**KIRKLEES METROPOLITAN COUNCIL
INVESTMENT & REGENERATION SERVICE**

**DELEGATED DECISION TO DETERMINE APPLICATIONS FOR
NON-MATERIAL AMENDMENTS**

Reference No: **2025/NM/91107/E**

Site Address: 5, Hopton Hall Lane, Upper Hopton, Mirfield, WF14
8EP

Client: LUMB		
Project: 5 HOPTON HALL LANE		
Drawing Title: GA PLANS - GROUND & FIRST FLOOR		
Stage: Planning	Status: S0	
Drawn By: JL	Date: April 21	Scale: As Noted
Job Number: 2005	Client Project Number: n/a	Sheet Size: A1
Revision: 2005-004		P03

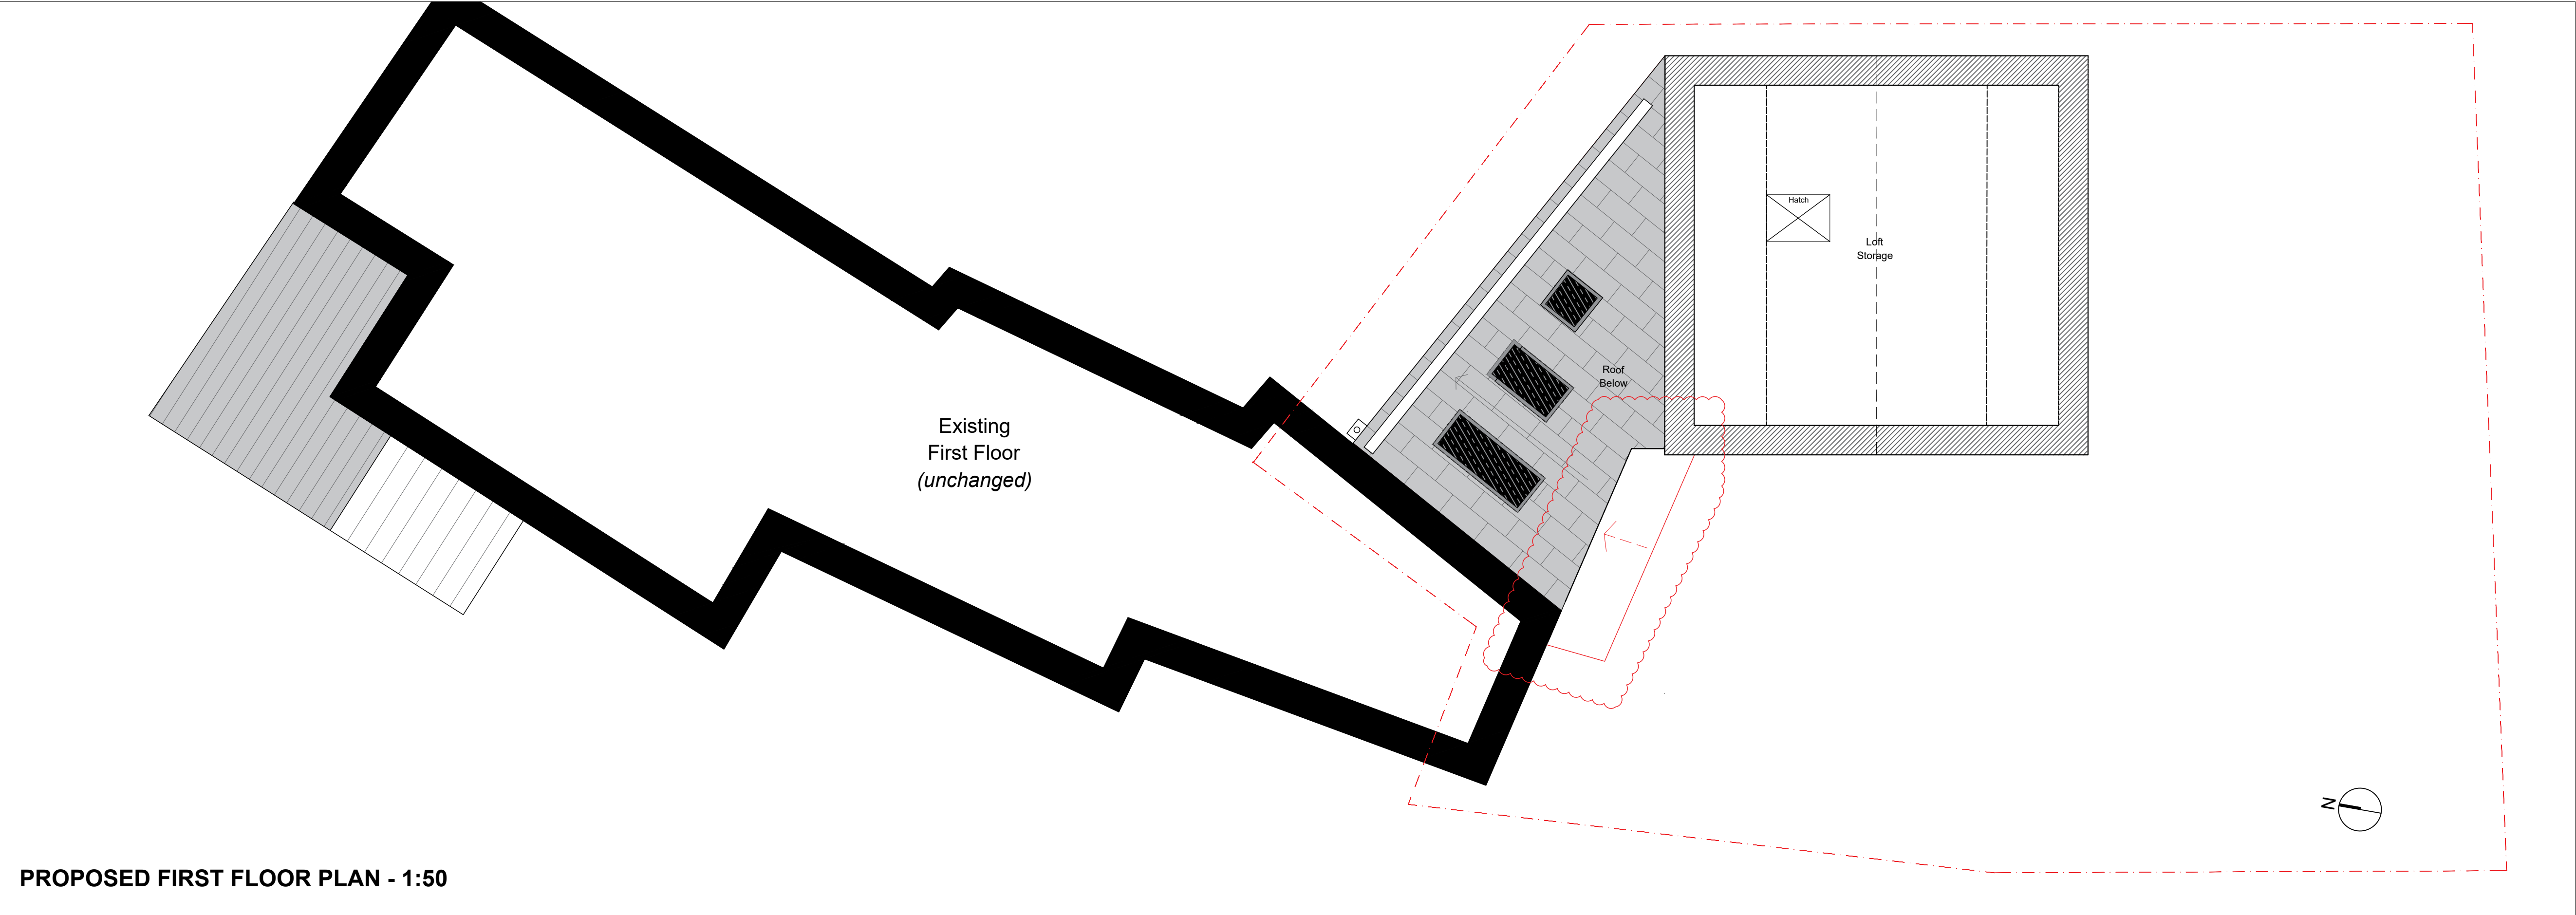
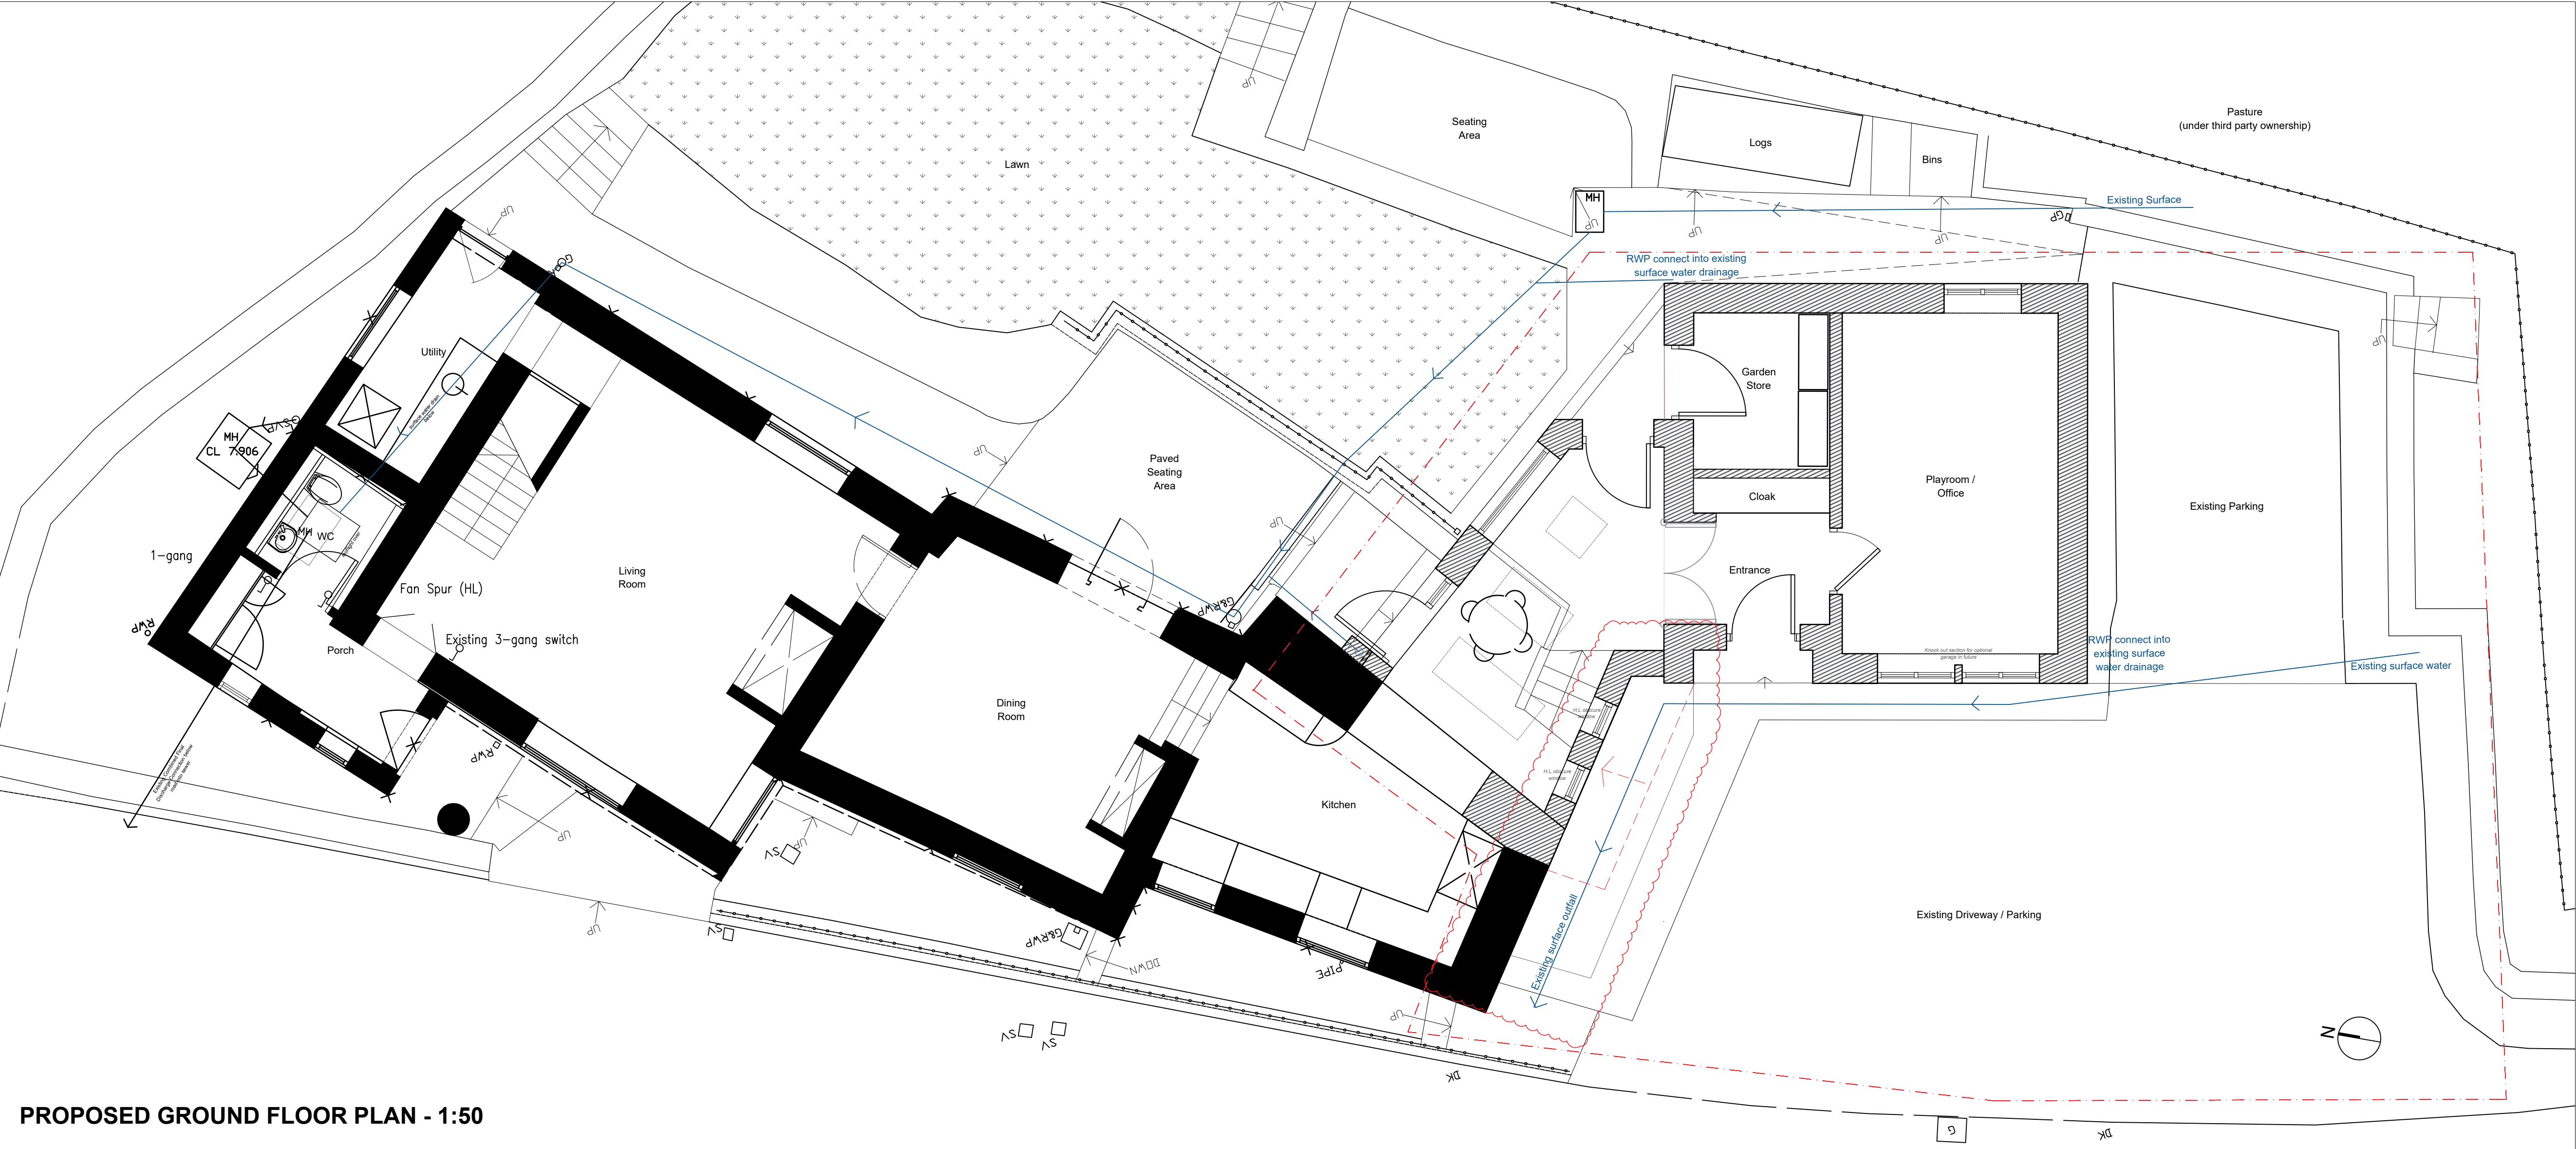
The principle of the volumetric increase was established pursuant to application 2022/90403. The amendment will set a wall of the link by 0.45m away from the side extension. The amendment represents a decrease in volume, which is inconsequential in terms of scale.

Client: LUMB		
Project: 5 HOPTON HALL LANE		
Drawing Title: PROPOSED ELEVATIONS		
Stage: Planning	Status: S0	
Drawn By: JL	Date: April 21	Scale: As Noted
Job Number: 2005	Client Project Number: n/a	Sheet Size: A1
2005-006		Revision: P03

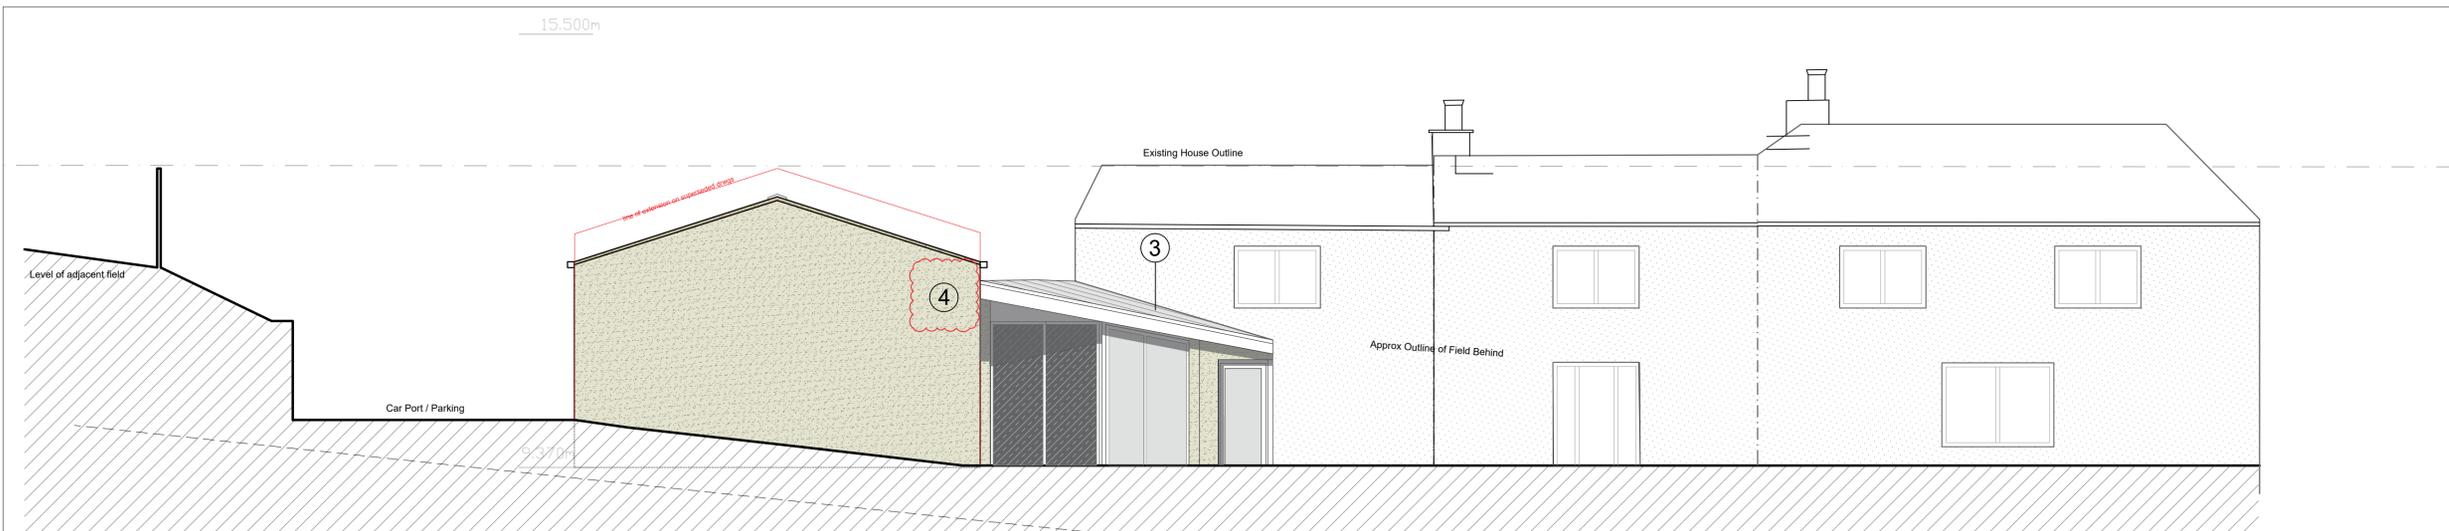
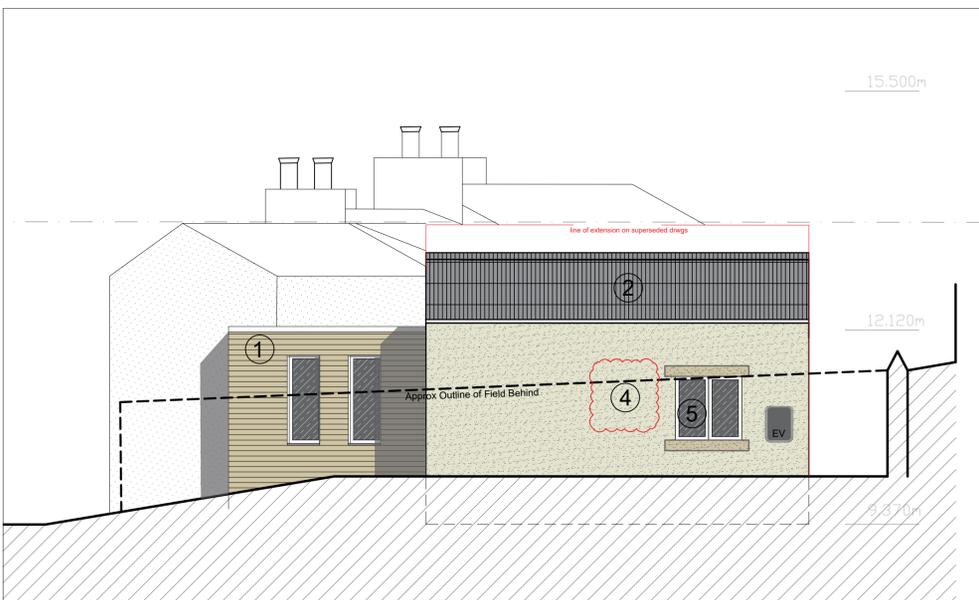
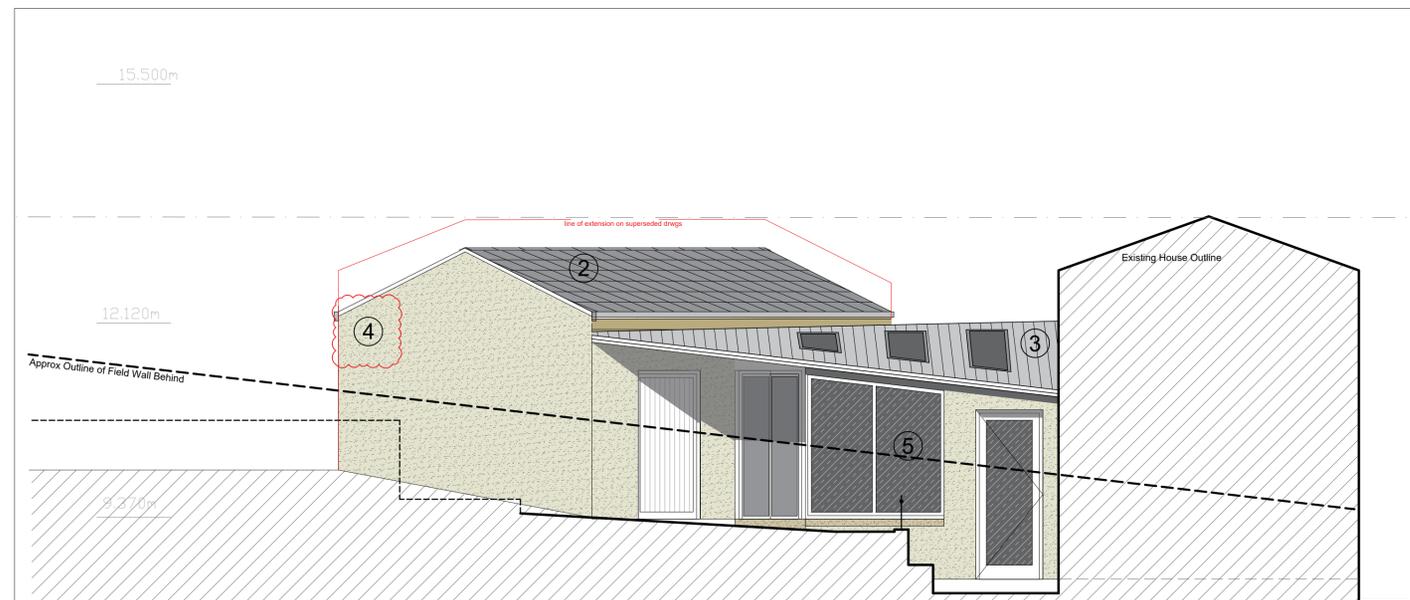
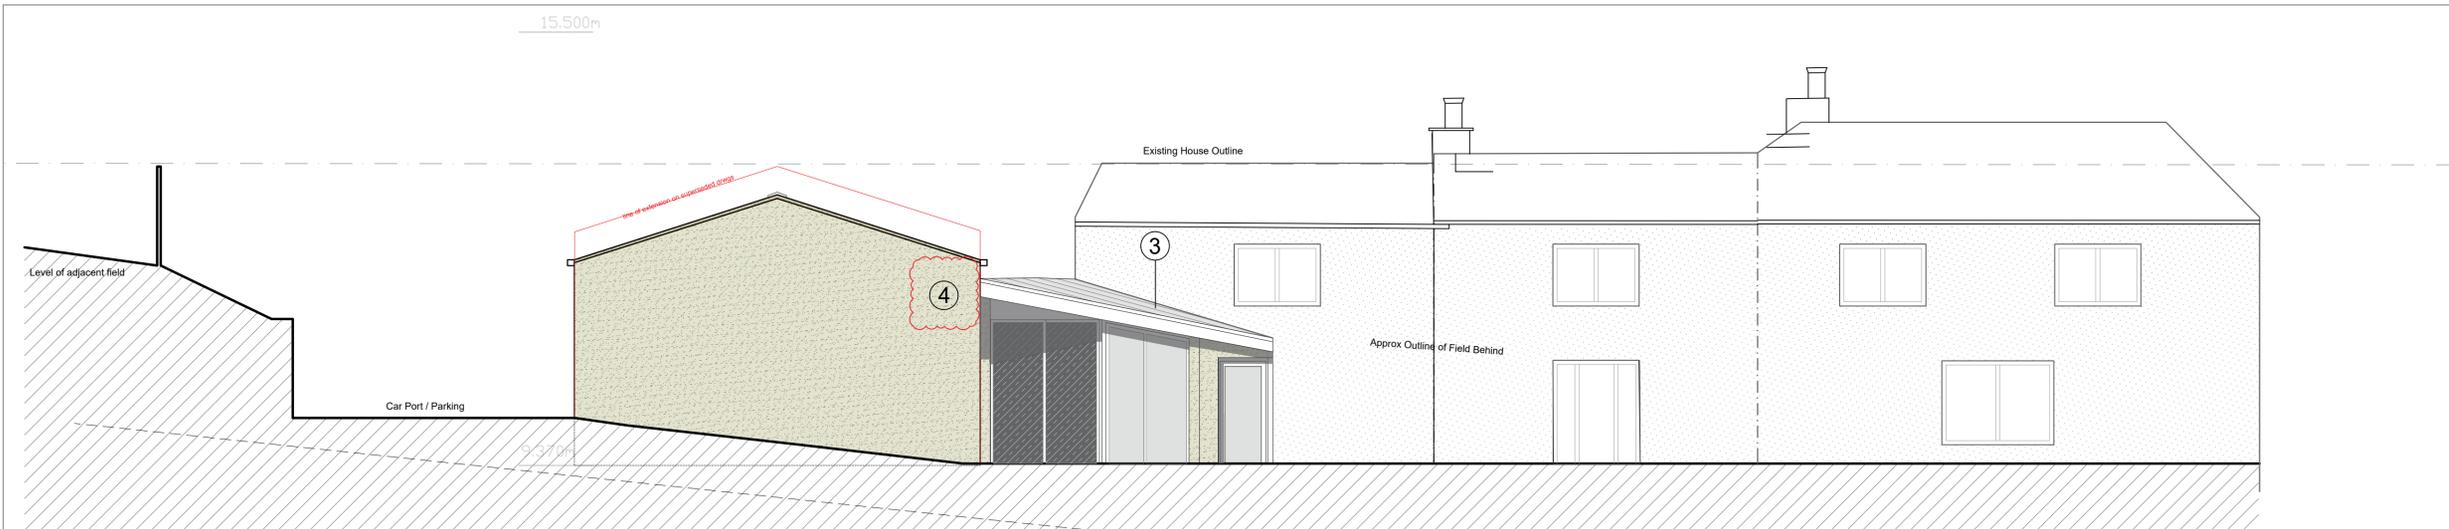
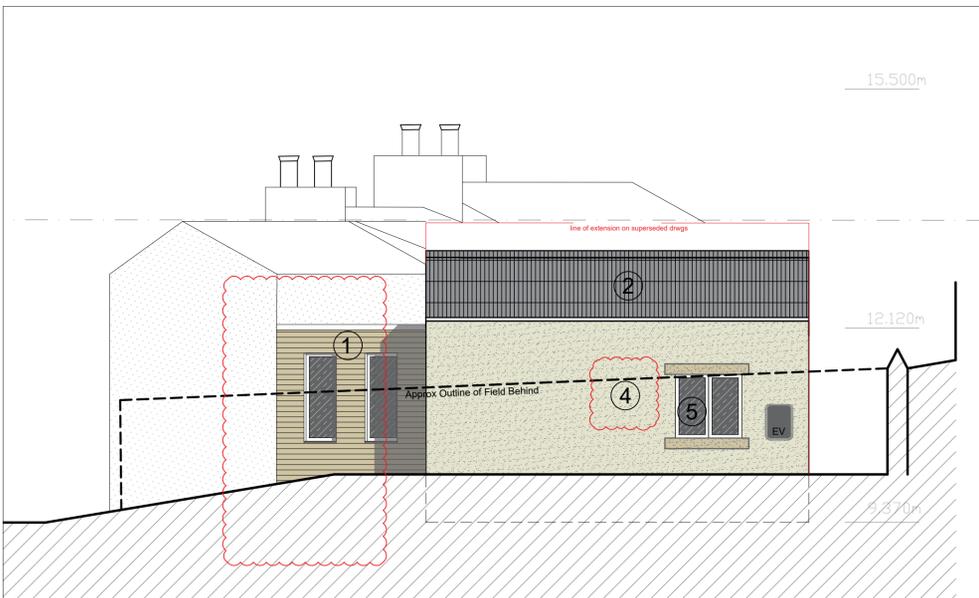
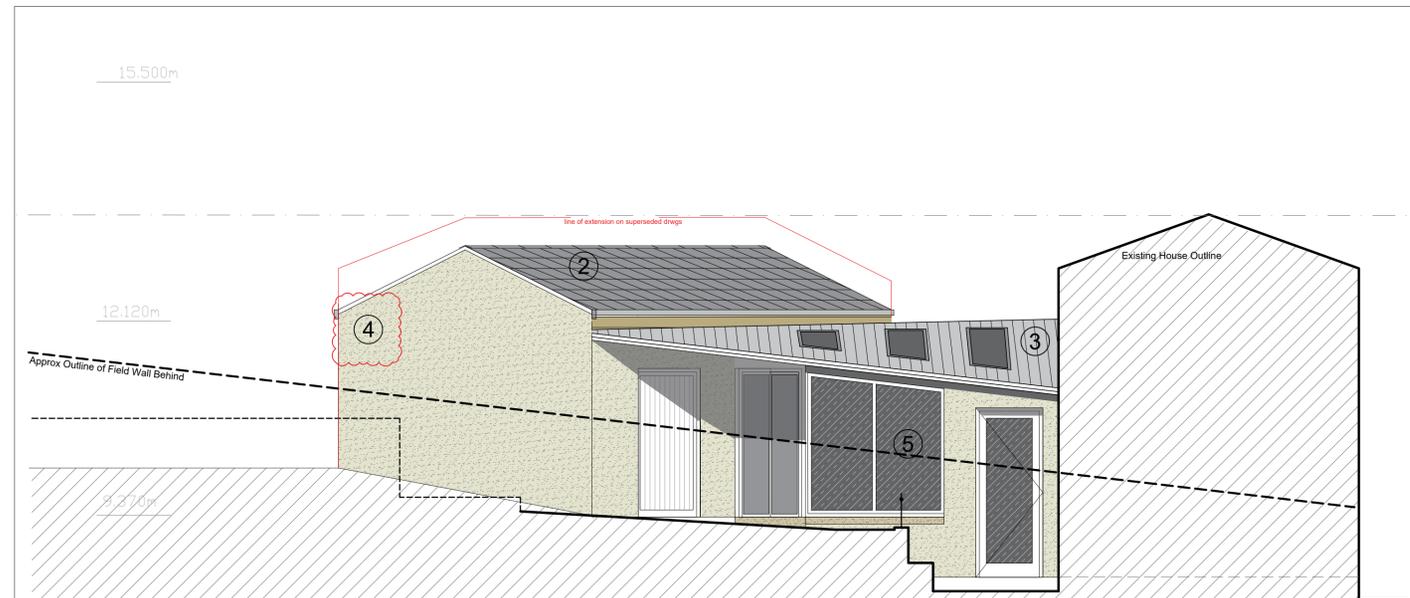
for a change of material to introduce render on the side and rear elevation of the side extension and render on the rear elevation of the link. The render would be a 'buff stone' colour.

In terms of an impact to the Green Belt setting, the extensions are set down marginally from fields to the east due to a change in land levels. Public Right of Way MIR/71/10 rest 100m to the east. The render will also be visible as vehicles and pedestrians travel northbound on Hopton Hall Lane.

The original application detailed natural buff stone on the side and rear of the dwelling, which is being changed to a render material. The material will be present from aspects on Hopton Hall Lane as people travel northbound. Given the Green Belt location of the building and the presence of these elevations, the material change would amount to a new Green Belt assessment, which would in turn not be inconsequential in itself. The change would be from a natural stone material which is commonly found in the Green Belt, to a render material presenting a visual change.

The proposed amendments to the materials of construction would conflict with Condition 4 of the original approval which states:

Notwithstanding the plans hereby approved, the external facing materials shall be exactly as labelled on dwg 2005-006 rev P02 and sampled on the submitted 'Materials Board (ref 2005-007).

Given the details were previously approved and conditioned to preserve the openness and rural character of the Green Belt, a new assessment must be undertaken. The applicant may wish to apply for a Section 73 application to vary Condition 2 & 4 of the permission reference 2022/90403 in this instance
